Tree Work Application Decision Notices

NOTICE OF REFUSAL OF CONSENT TO FELL AND/OR PRUNE

Application Number: 2026/90579

At: St Marks Church, St Mark's Road, Longwood, Huddersfield, HD3 4SZ

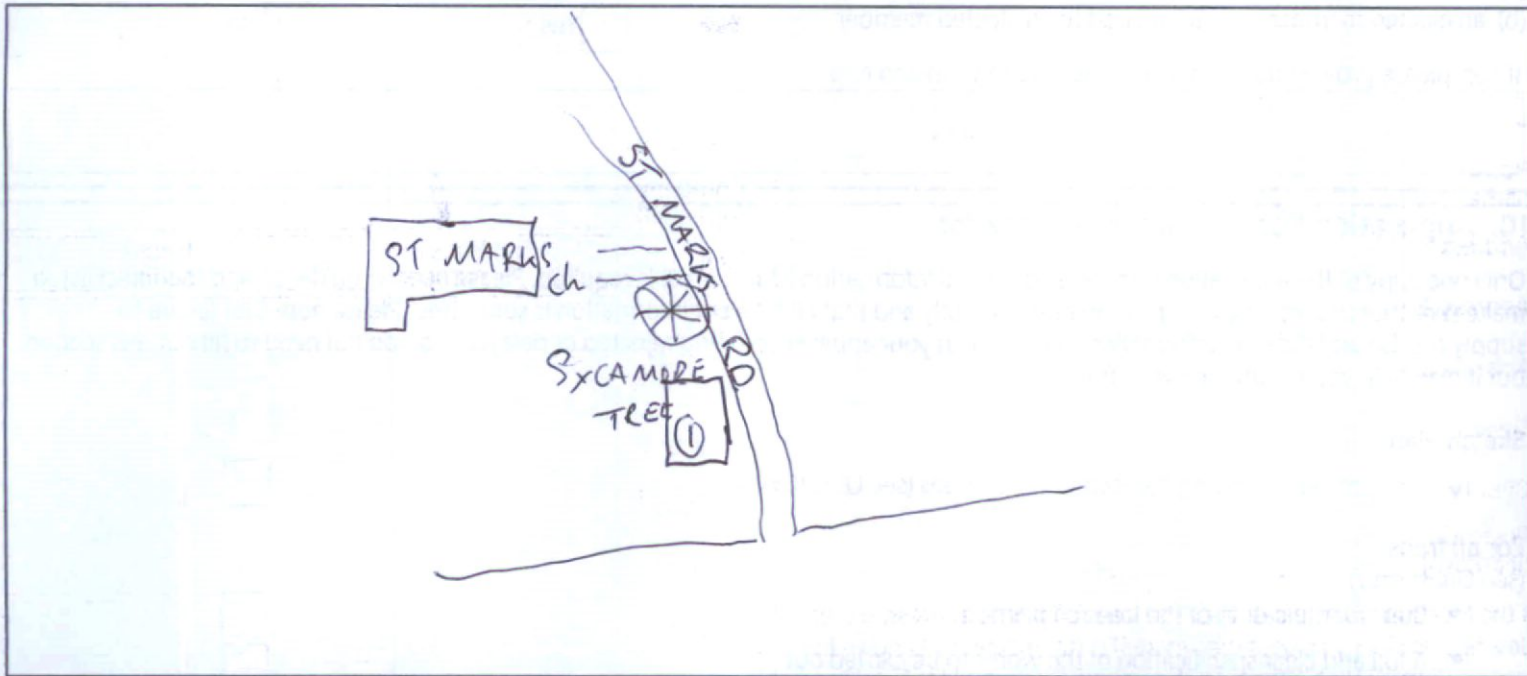
1. The submitted application isn't clear enough which tree it is proposing to fell. There are many sycamore within this area and the sketch plan does not accurately identify an individual tree.
2. There was no evidence submitted within the application (photographs or written report) that shows the basal wound or the extent of decay poses any abnormal risk to health and safety.
3. This tree is a prominent landscape feature in the locality and as such contributes significantly to public amenity consequently the grounds for its removal must be weighed against the amenity it provides.
